Norwich to Tilbury

Document: 9.2 Notification of proposed change to DCO application -
Change Request 2 (Little Bromley)

Planning Inspectorate Reference: EN020027

Little Bromley: Change to the EACN access (Change Request 2)

Legend
 Proposed Change Project Design
 Proposed change Order Limits

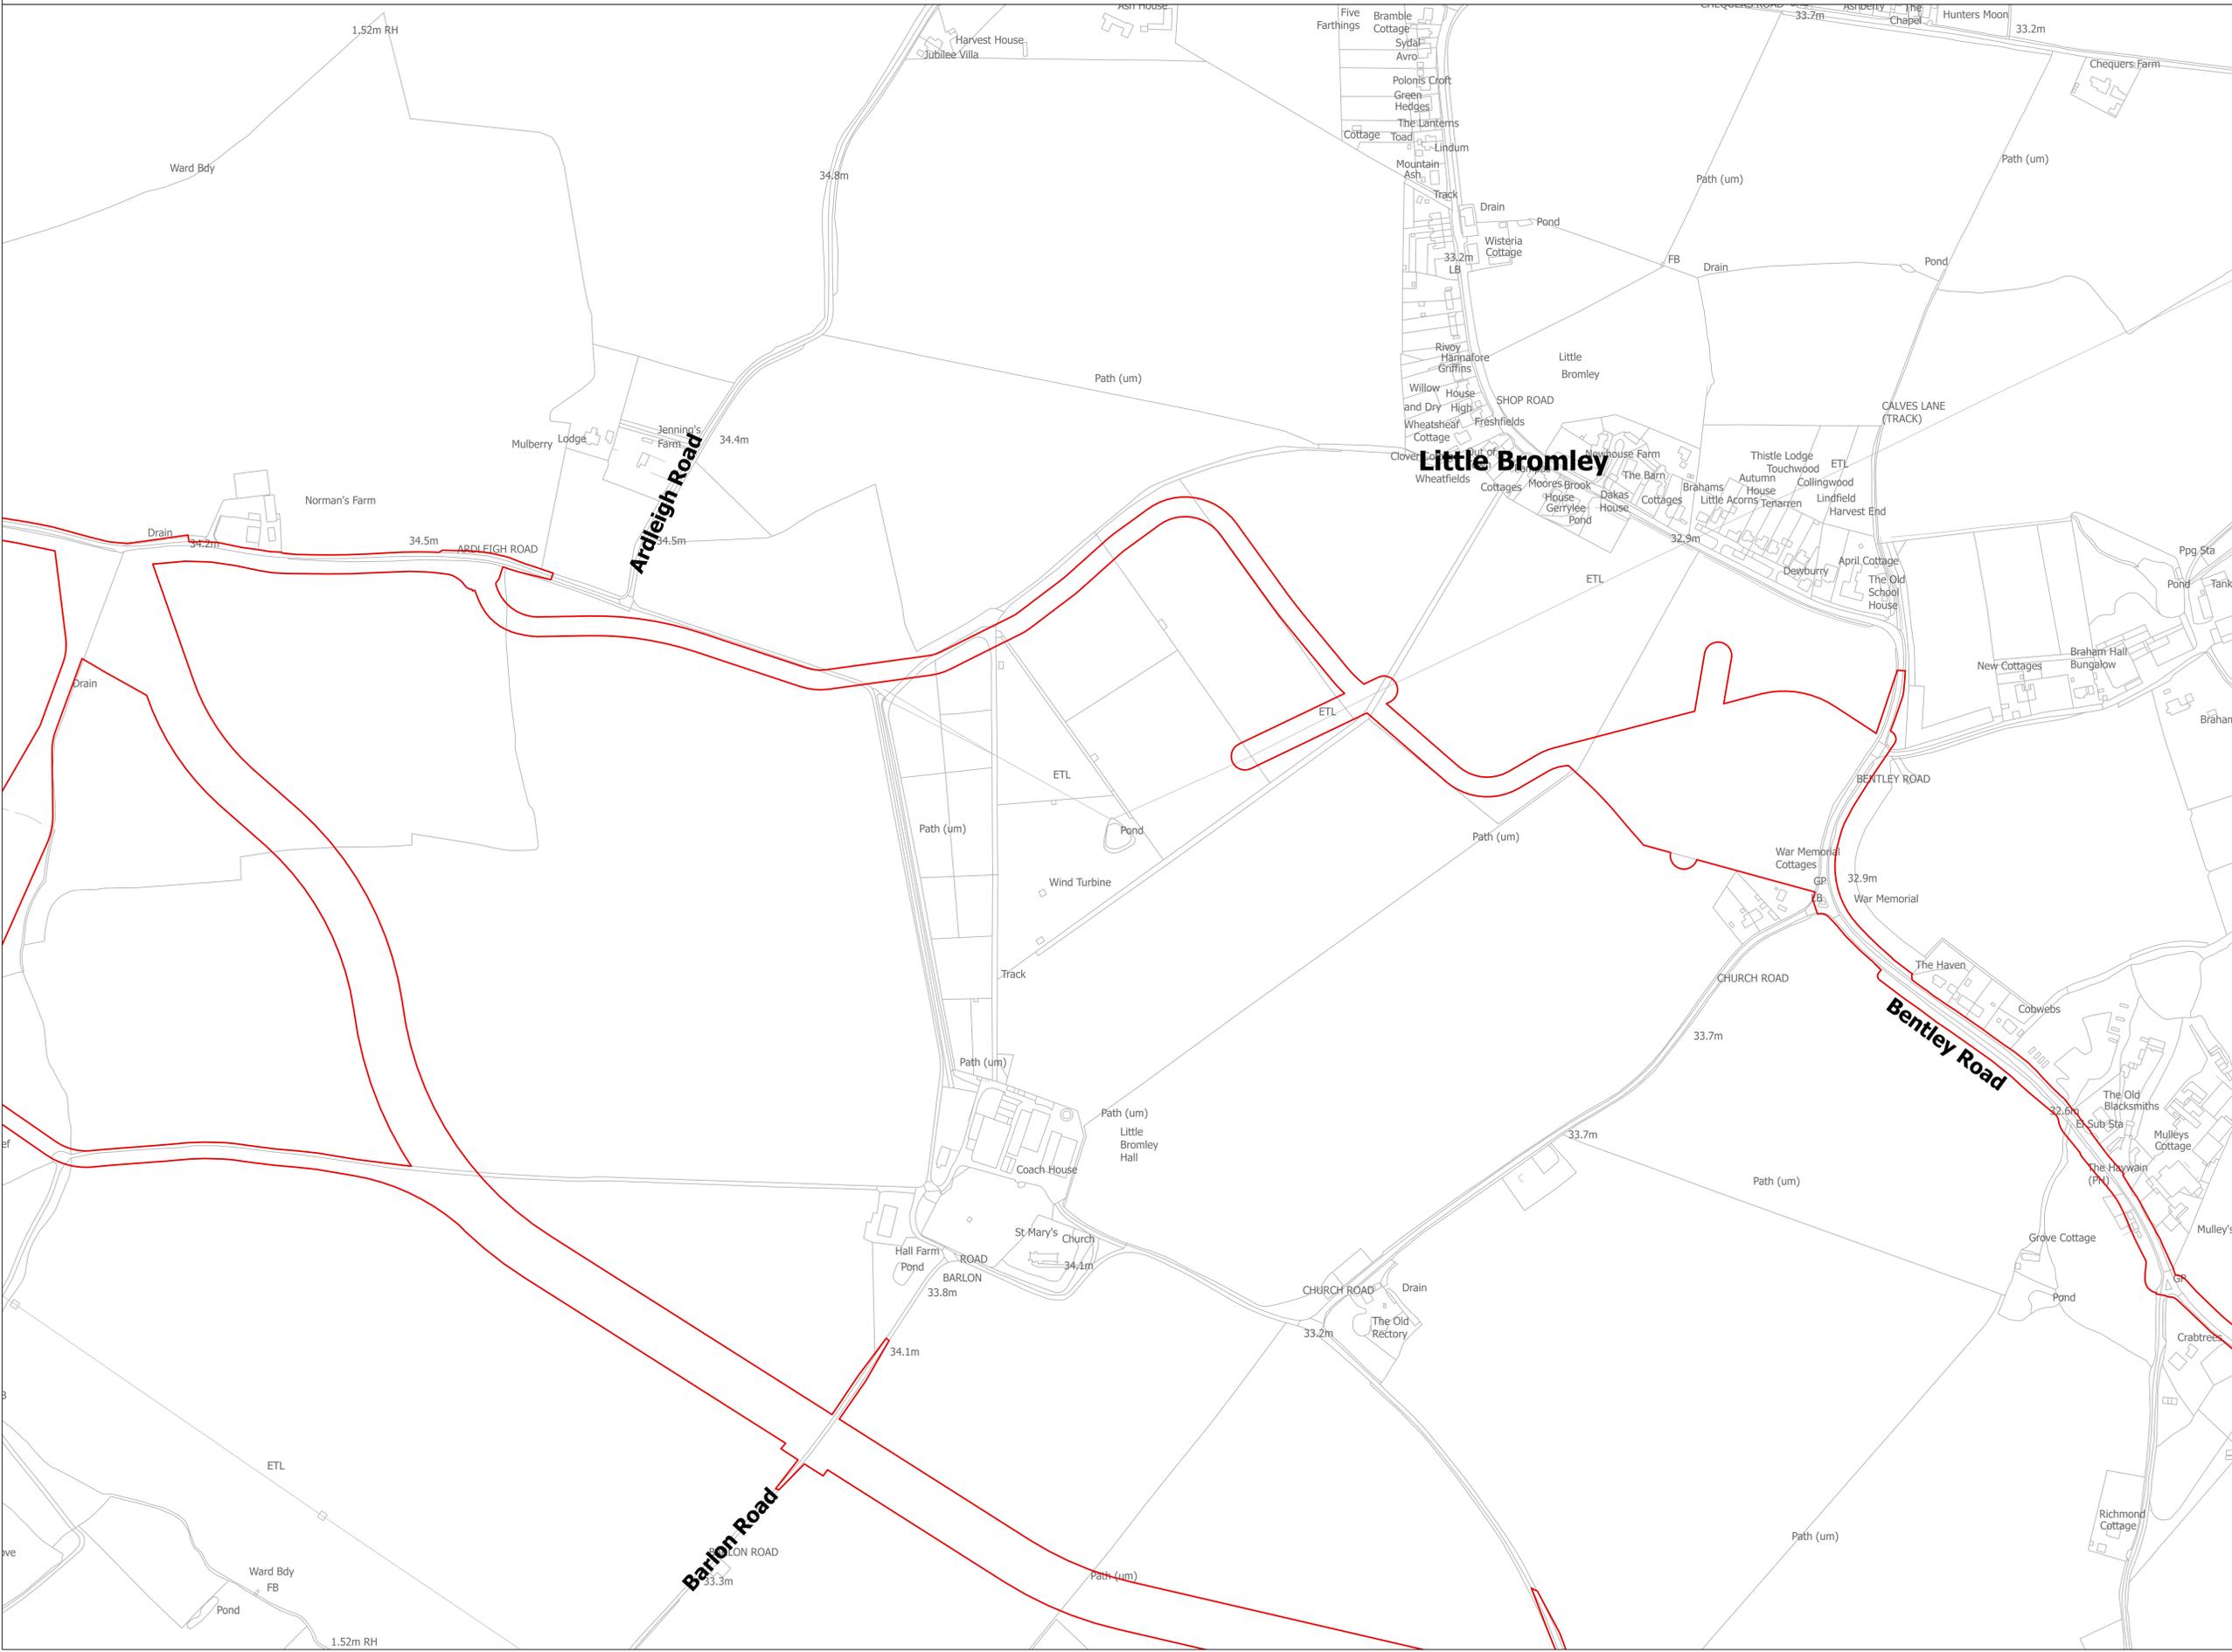
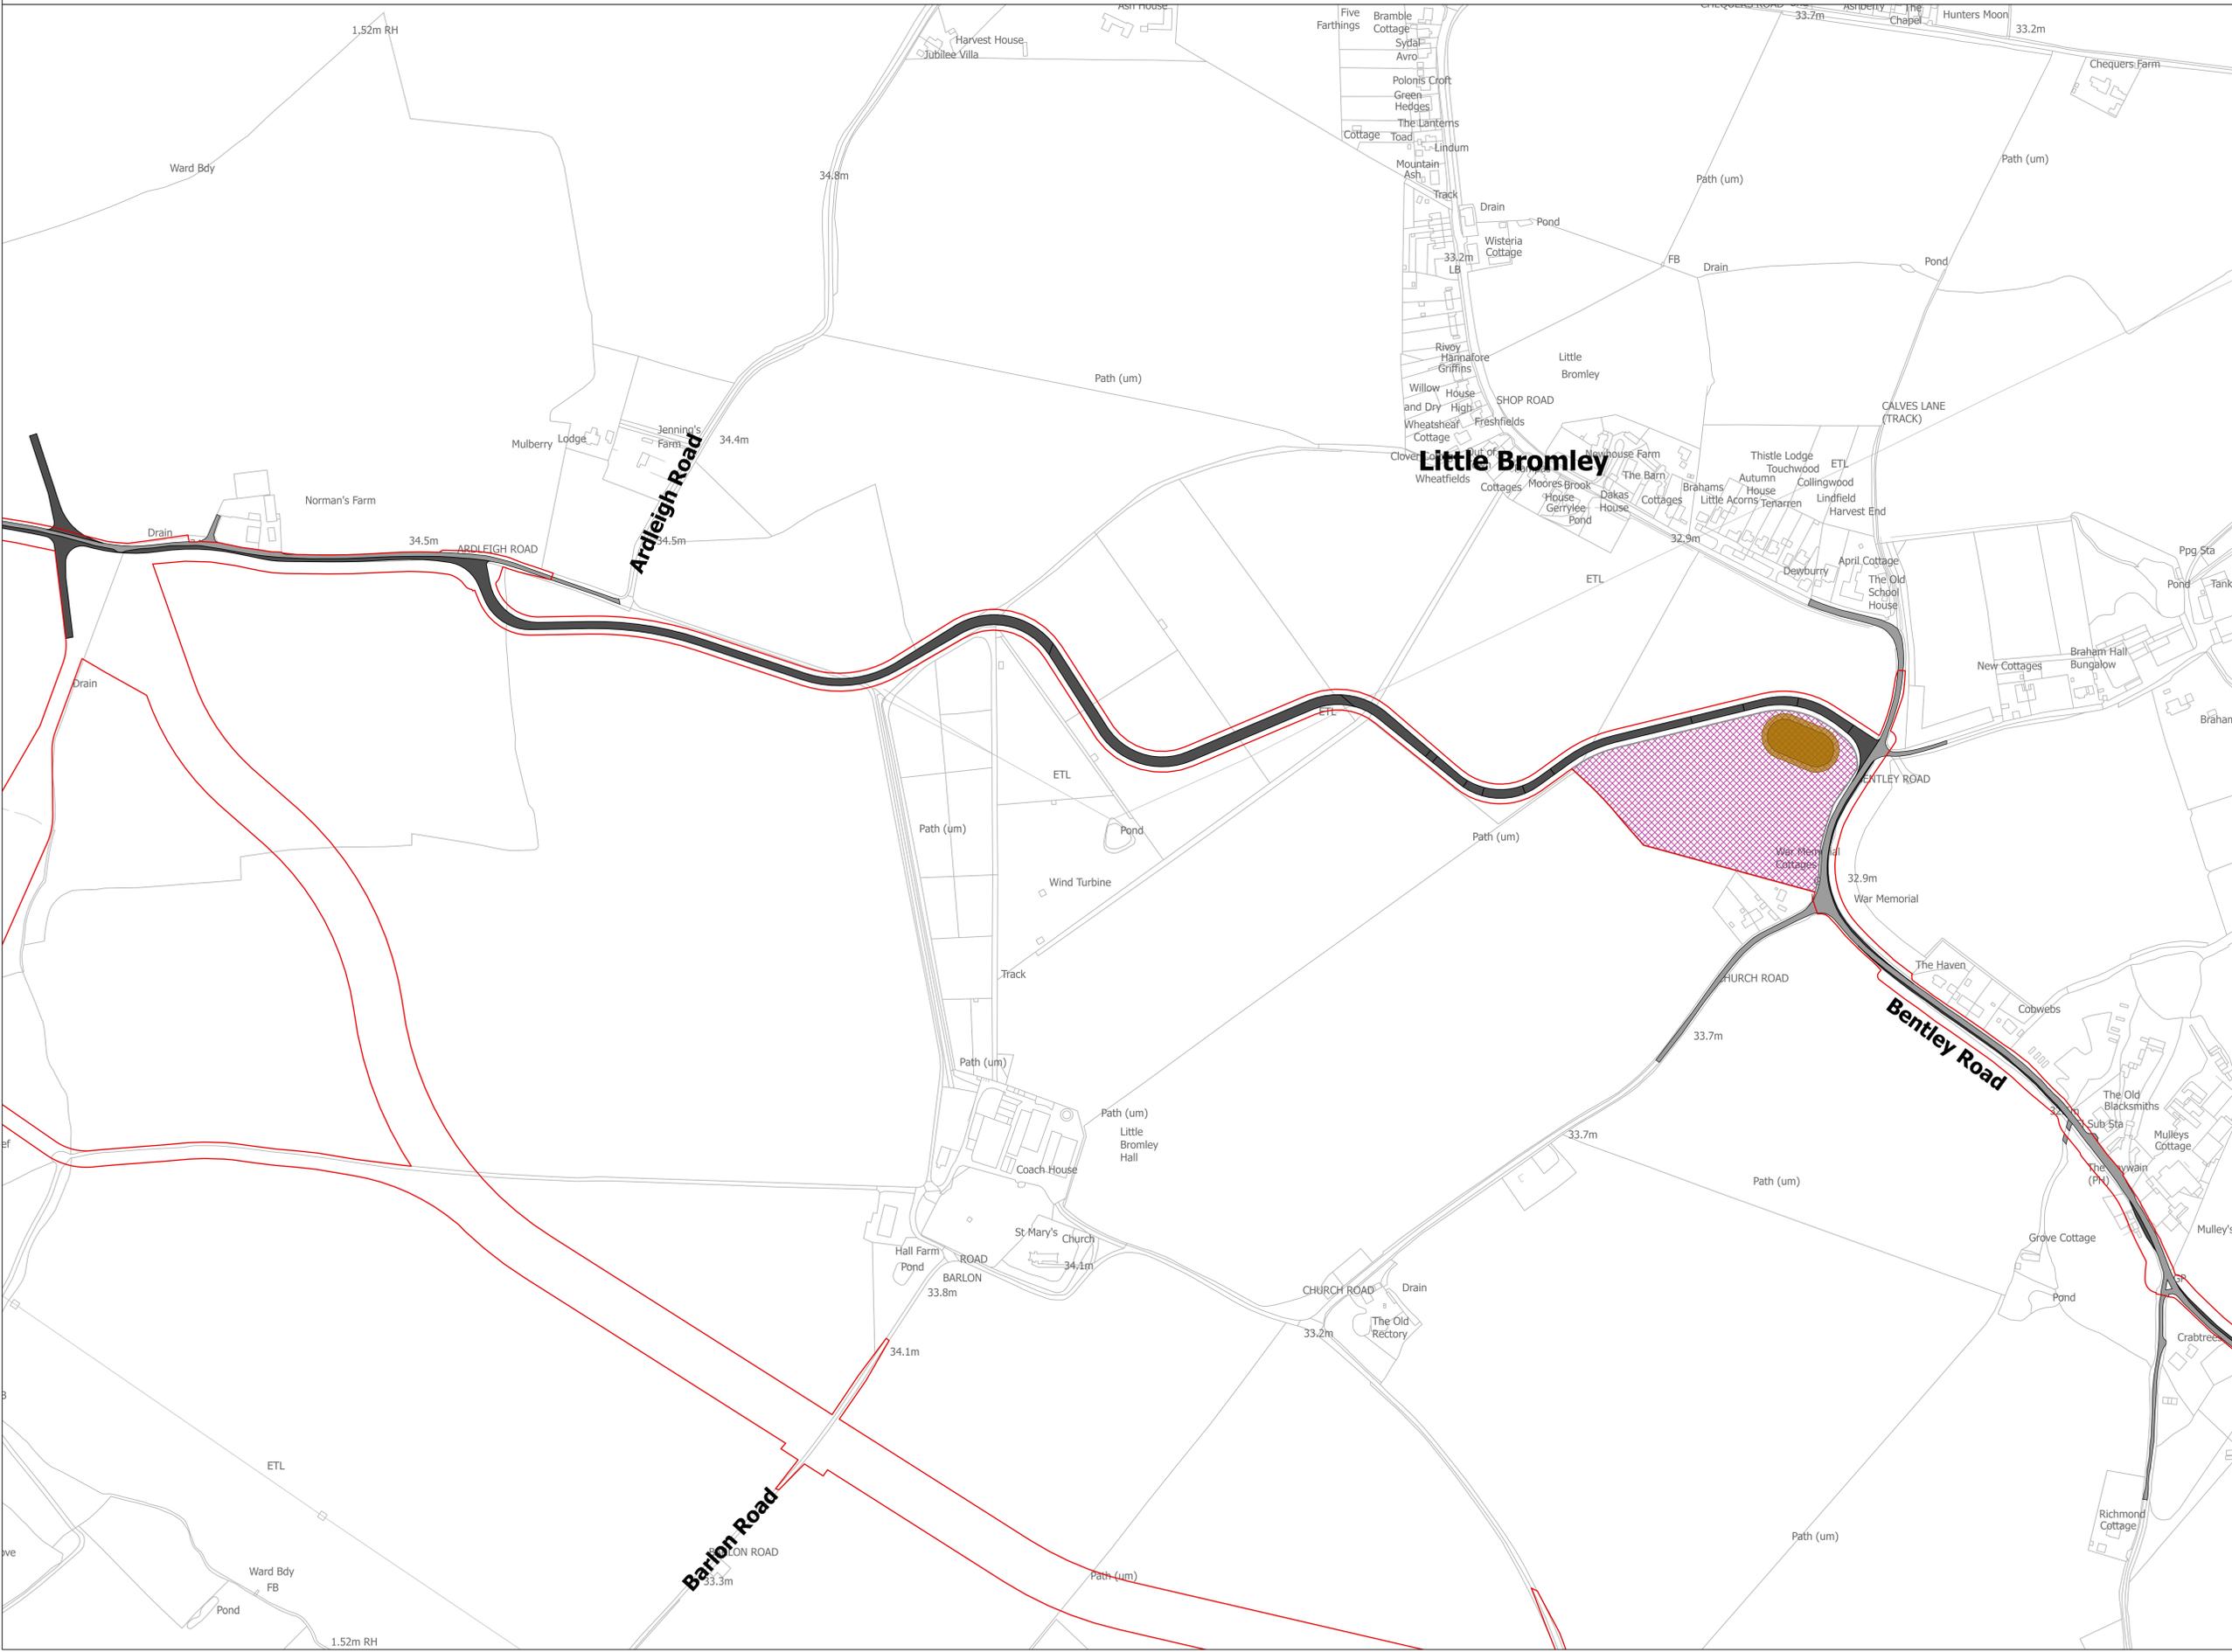
- 2.1.7 Change Request 2 would involve two modifications to the Proposed Route;
- Firstly, a section of the Proposed Route nearest to Bentley Road has been amended to provide a modified alignment for the permanent access relating to Abnormal Indivisible Loads ("AIL") during the operational phase of the Project. The need for a permanent AIL route is to ensure supply standards for the connection are met in the future (by allowing replacement of any component at short notice).

- Secondly, to the northwest of the first modification, the Proposed Route, for both construction and operational vehicles, has been changed back to the alignment presented at statutory consultation between 10 April to 26 July 2024.

- 2.1.8 In both cases, the modifications respond to feedback from, and ongoing detailed discussions with, affected landowners in order to secure an operational access arrangement that meets the Project need whilst also facilitating ongoing land management. The first modification (concerning the AIL arrangement) is intended to minimise the effects of the Project on future arable cropping, whilst the second modification ensures that the Proposed Route more closely follows field boundaries.

- 2.1.9 Additionally, precautionary amendments to existing wood pole supported infrastructure will be accommodated as part of Change Request 2.
- 2.1.10 The Applicant considers that the proposed change will not result in any new or different likely significant environmental effects to those reported in the **Environmental Statement (ES) (APP-123 to APP-287)**. This will be confirmed in an Environmental Statement Addendum Report that will be submitted with the Proposed Change Application 2. The proposed change is not considered to affect compliance of the Project with planning policies detailed in the **Planning Statement (APP-085)** and **Policy Compliance Document (APP-086)**.

- 2.1.11 The arrangement has been subject to extensive discussion and consideration of alternatives with relevant landowners.
- 2.1.12 The Order Limits are to be amended as a consequence of the proposed change, with powers of compulsory acquisition and temporary possession to be sought by the Applicant over the additional land intended to be brought within the Order limits. Accordingly, the CA Regulations are engaged.
- 2.1.13 The Applicant has therefore sought the consent of those landowners to the inclusion within the draft DCO (if granted) of compulsory acquisition powers for new land and rights in respect of the land affected by the proposed change. However, it has not been possible to obtain such consent in advance of issuing this change notification.
- 2.1.14 The proposed change to the Order Limits is shown on the figures in **Appendix A**.
